Appeal Decision

Appeal Ref: APP/Z4718/D/24/3354647

5 Chestnut Avenue, Staincliffe, Batley WF17 7DH

- The appeal is made under section 78 of the Town and Country Planning Act 1990 (as amended) against a refusal to grant planning permission.
- The appeal is made by Mr U Bostan against the decision of Kirklees Metropolitan Council.
- The application Ref is 2024/62/92383/E.
- The development proposed was originally described as 2 storey side and rear extension, single storey front extension.

REGULAR COURSED NATURAL YORKSHIRE STONE
PROPOSED FRONT ELEV. (WEST)

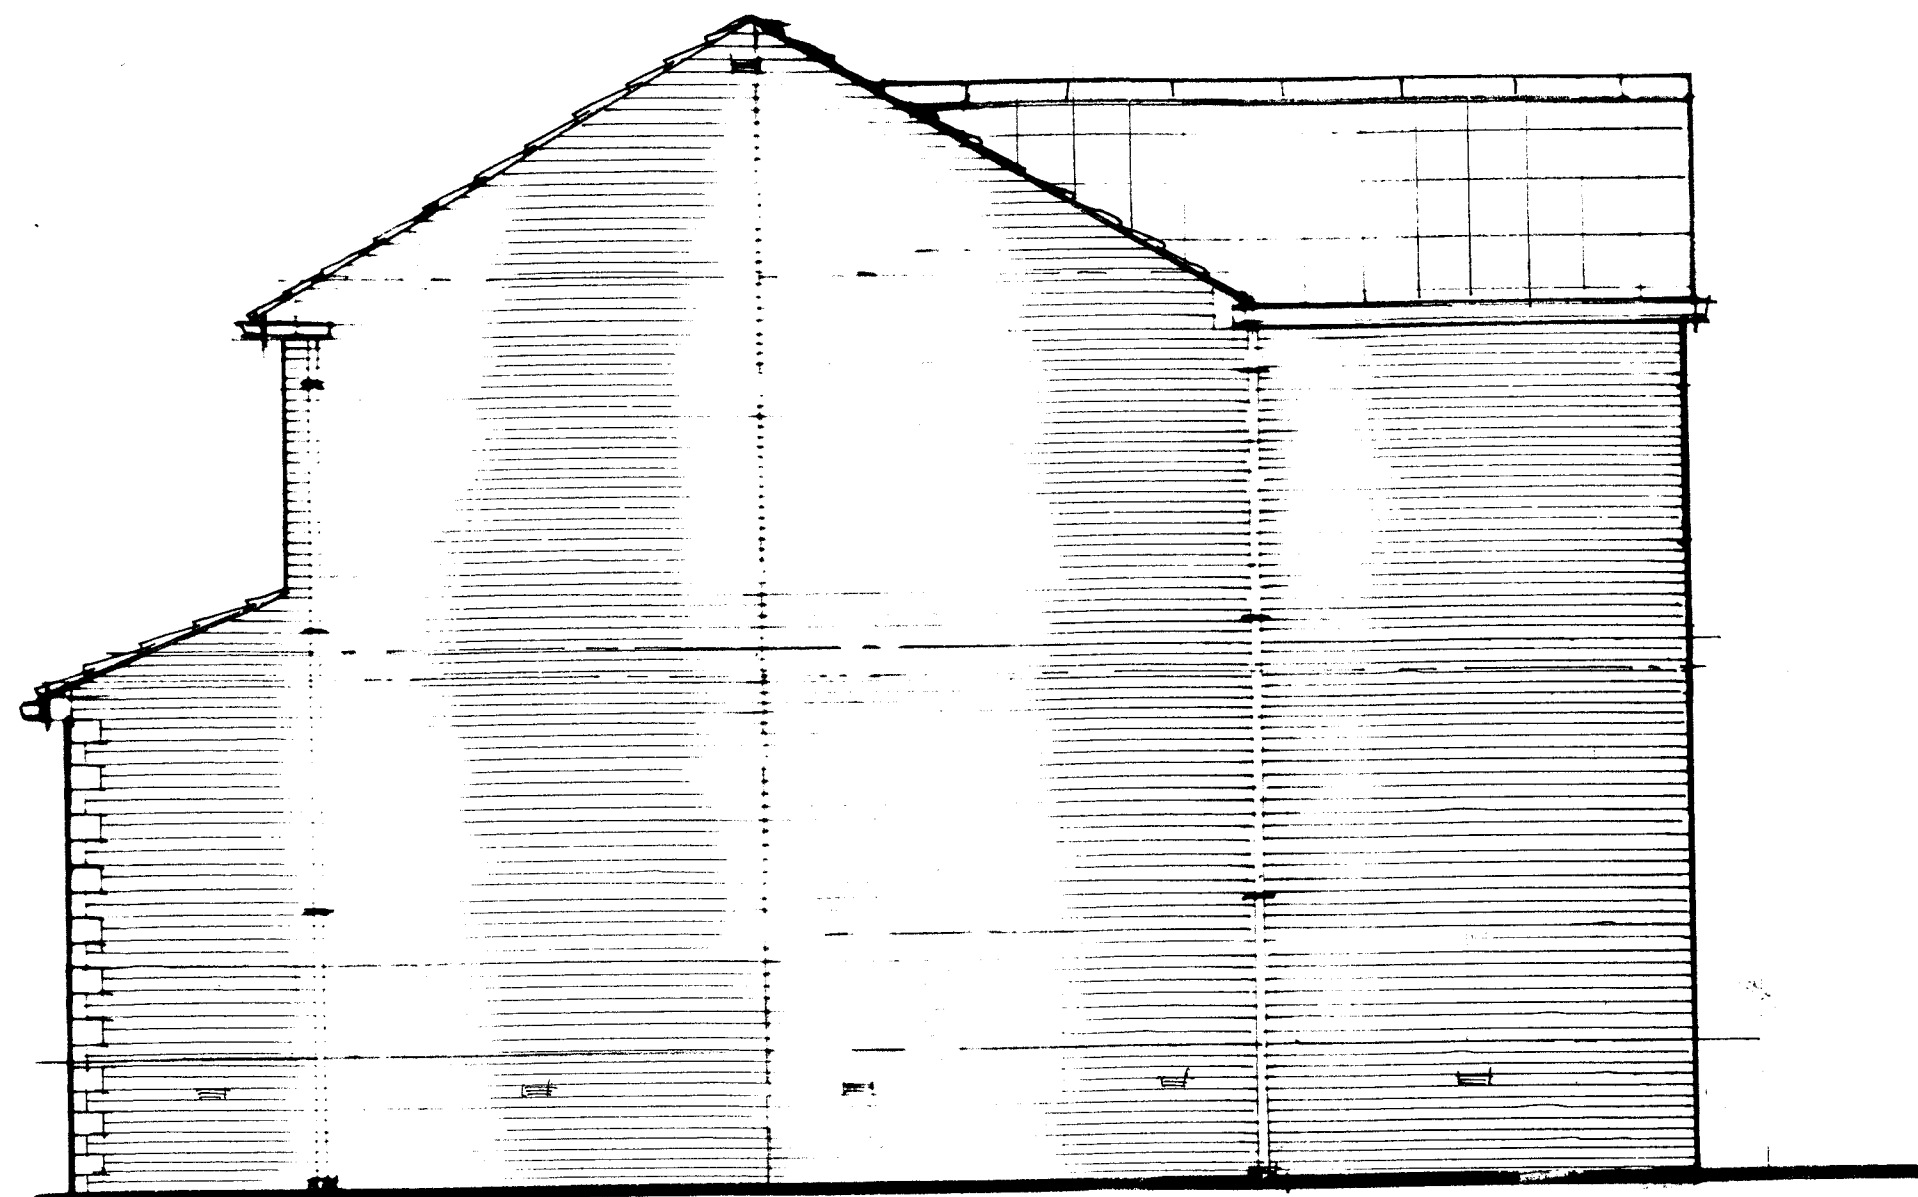
6. Although there would be a gap between the extension and the common boundary shared with No 3, the extension would take up most of the space to the side of the property. As a result of this and No 3's extension, there would be a very small gap between Nos 3 and 5. Furthermore, the extension would not be set back from the existing frontage of the dwelling or set down from the existing roofline. The gap between Nos 3 and 5 would be apparent when stood in front of the dwellings, but when viewed from the majority of Chestnut Avenue it would not be evident.

7. The extension would result in the appearance of terraced housing from Nos 1–7 due to the combination of the small gap to the side boundary, lack of set down and set back, and existing extensions. Thus, the development would not be in keeping with the pattern of development and spacing between dwellings, which would erode the sense of space. The extension would therefore not respect or enhance the character of the townscape.

PROPOSED SIDE ELEV. (SOUTH)

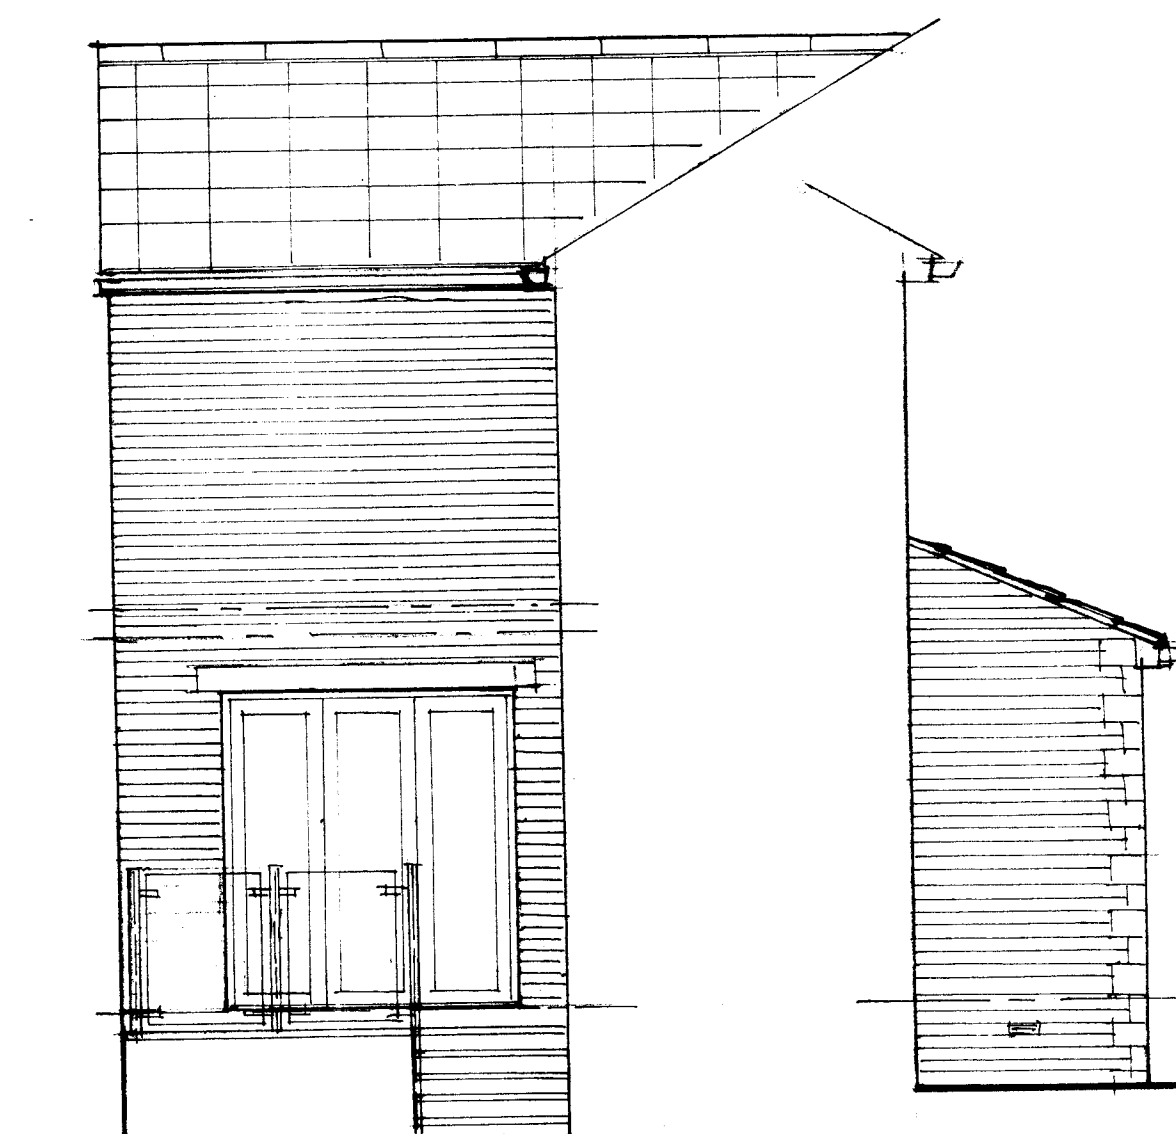
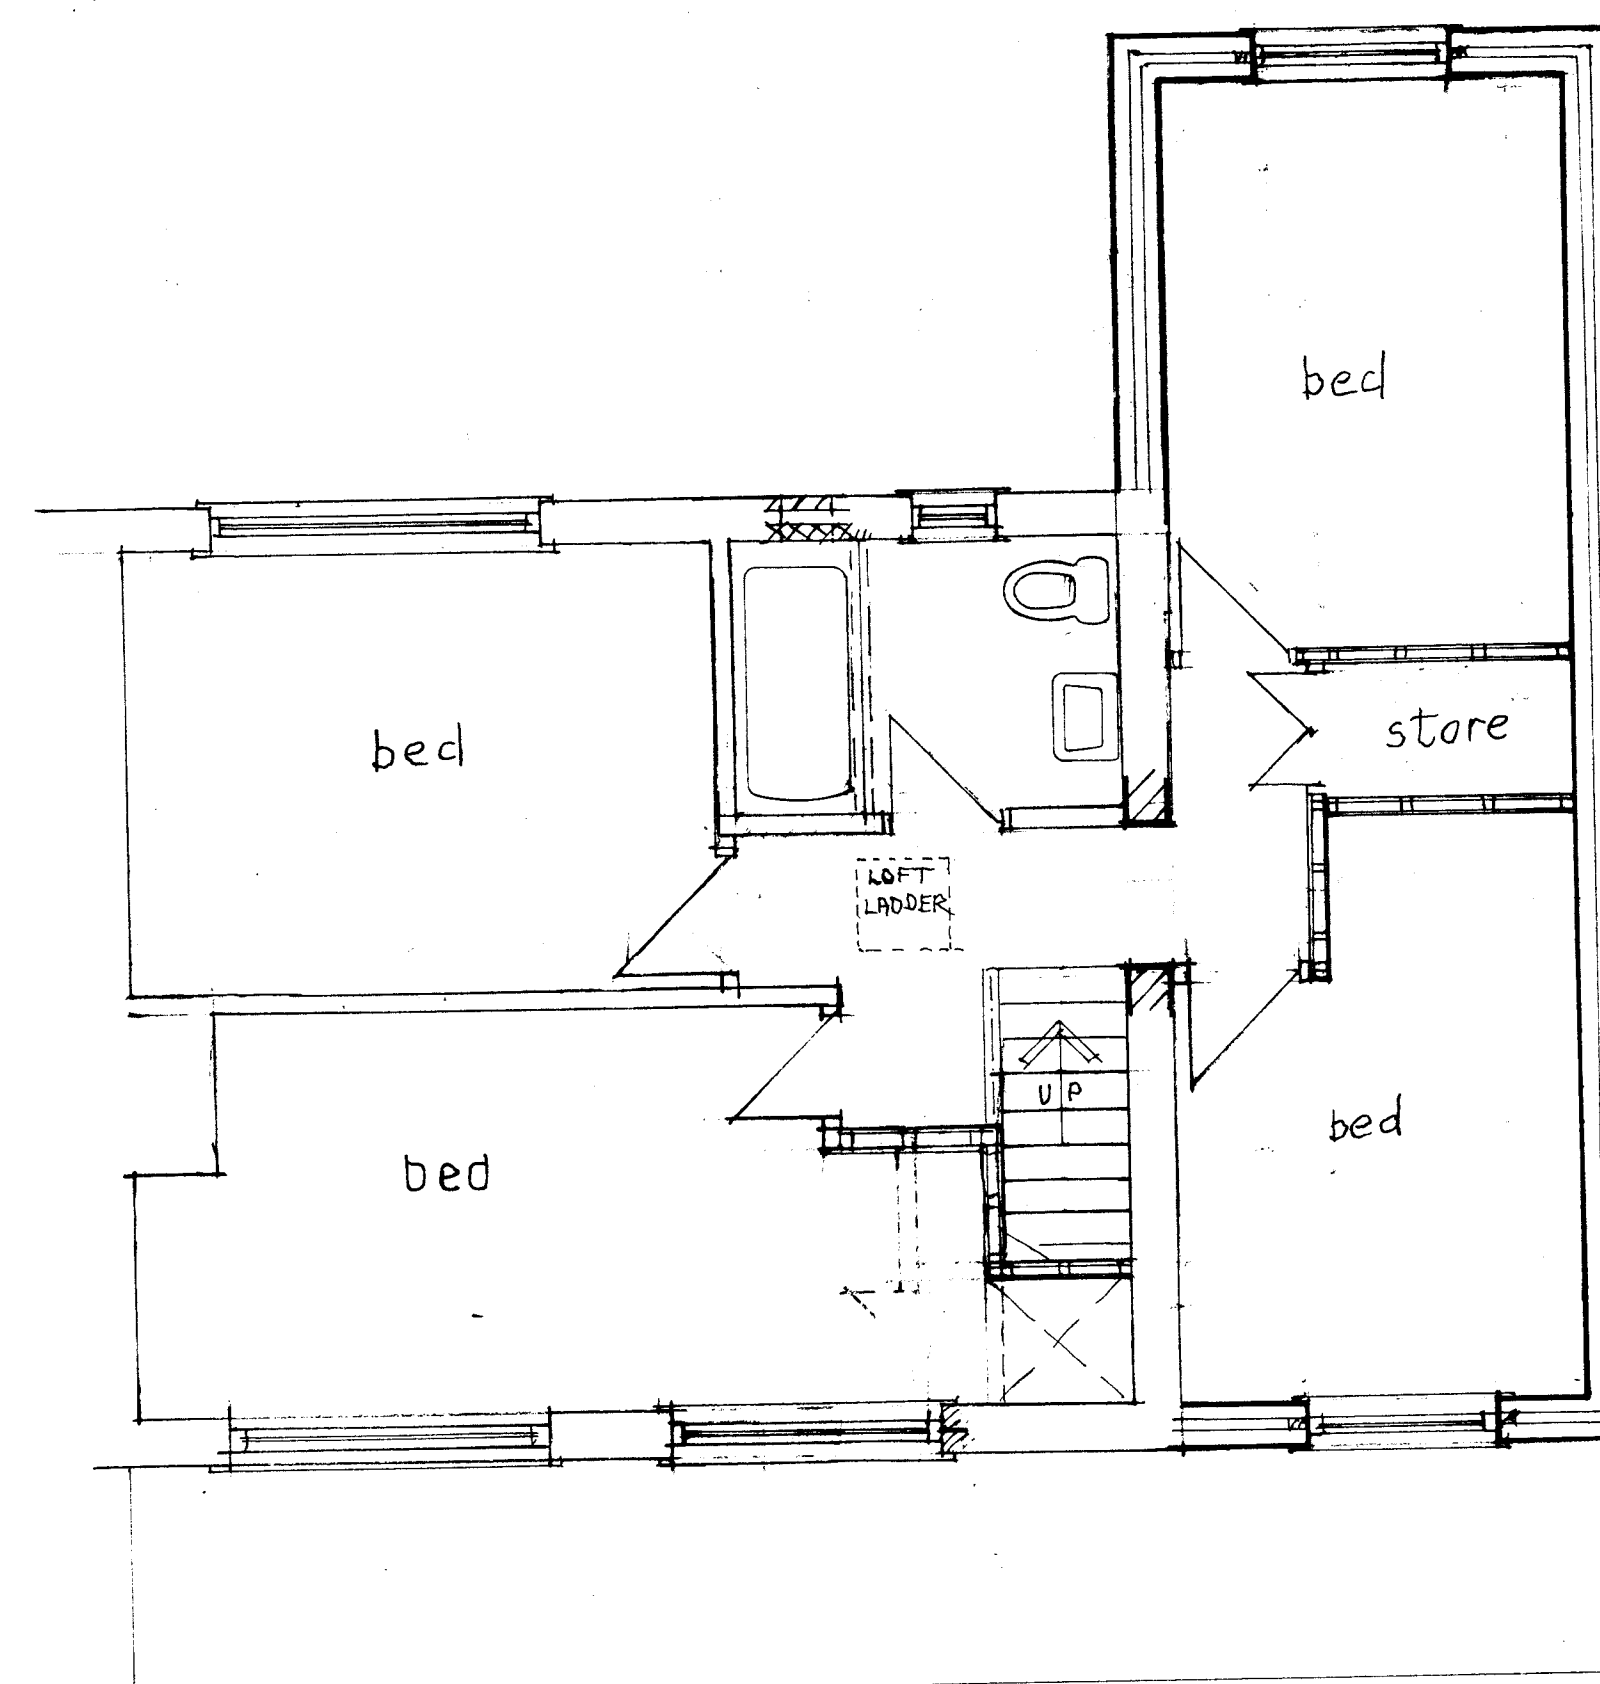
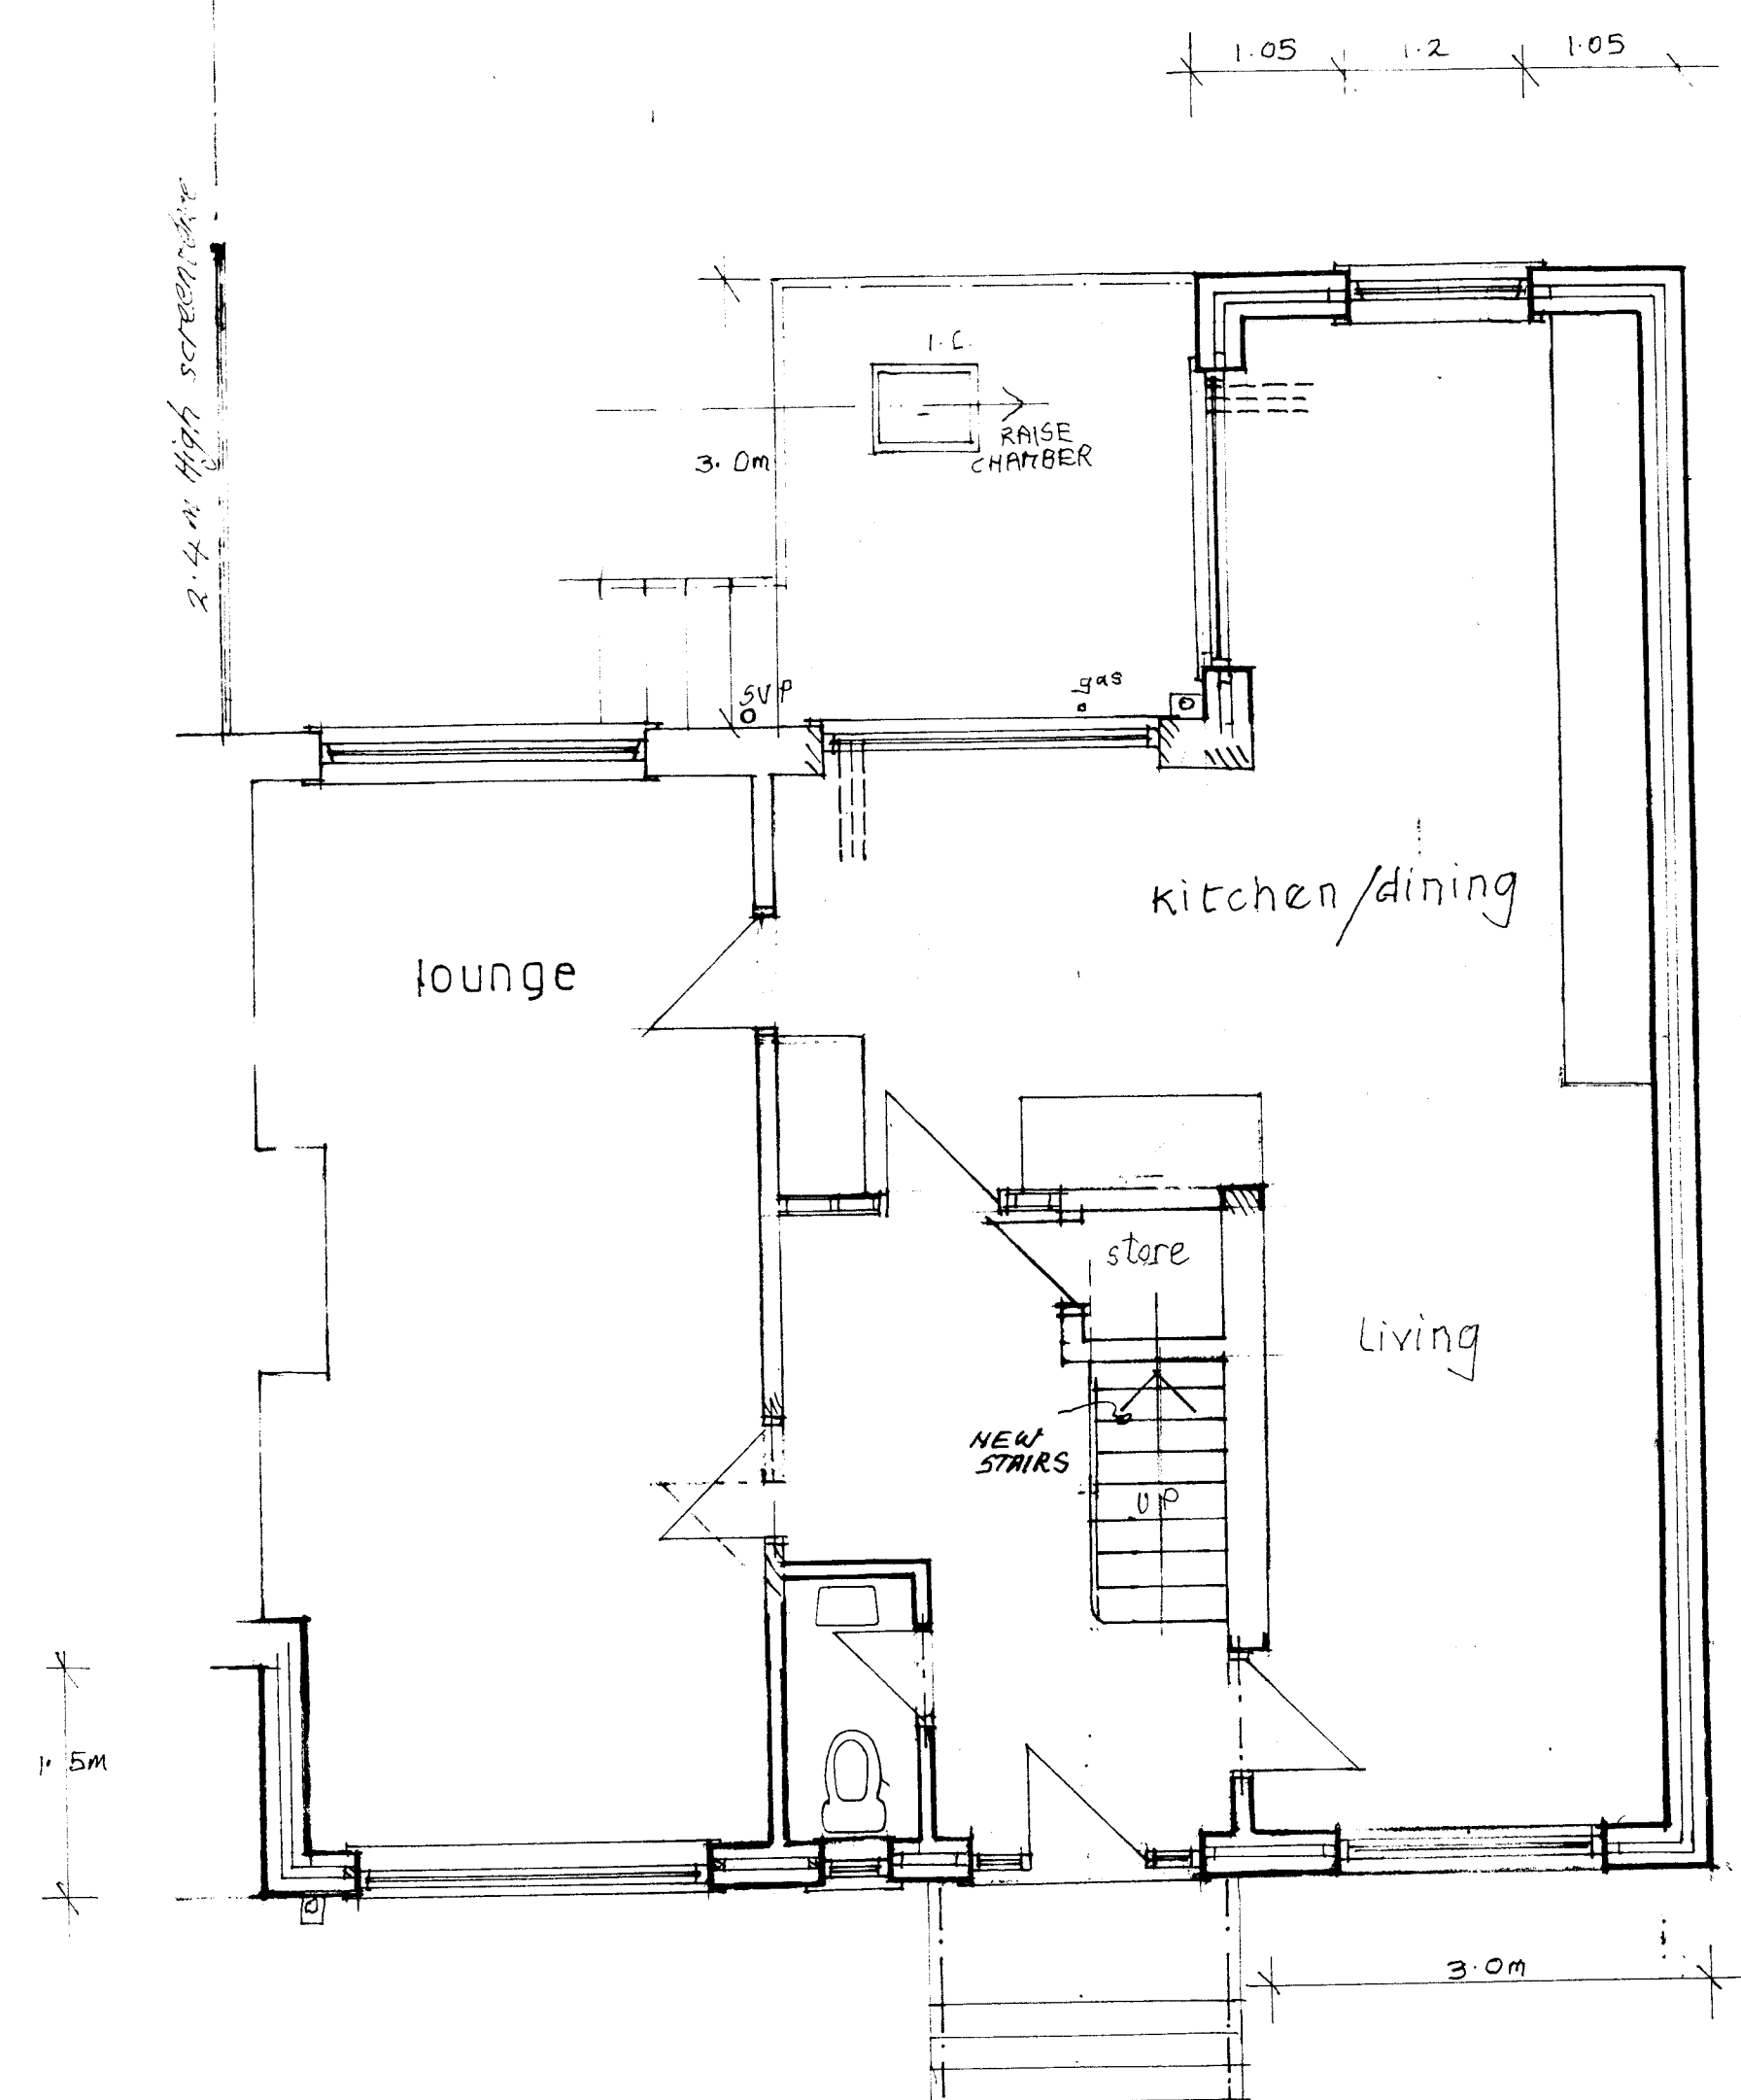
9. No 3 has windows which face the appeal site. I understand that one of these windows serves a living room. The appellant highlights that this window was approved as a high level window and they could construct a 2 metre high fence along the boundary. Whether a different kind of window should have been used is not for me to determine, and this is a matter for the Council. I am required to assess the proposal based on the plans before me and site circumstances, and it appears a window of some form was granted on this side elevation.

11. The development would result in a two-storey extension in close proximity to the living room window. There would be an extremely limited gap between this window and the extension. As a consequence, the extension would have an overbearing effect on the outlook of the living room window and would result in a loss of light. Thus, by virtue of the extension's scale, massing and siting and sun's path, the proposal would unreasonably overshadow No 3's living room window and the extension would be a dominant addition when viewed from this window. As a result, occupiers would feel unduly hemmed in.
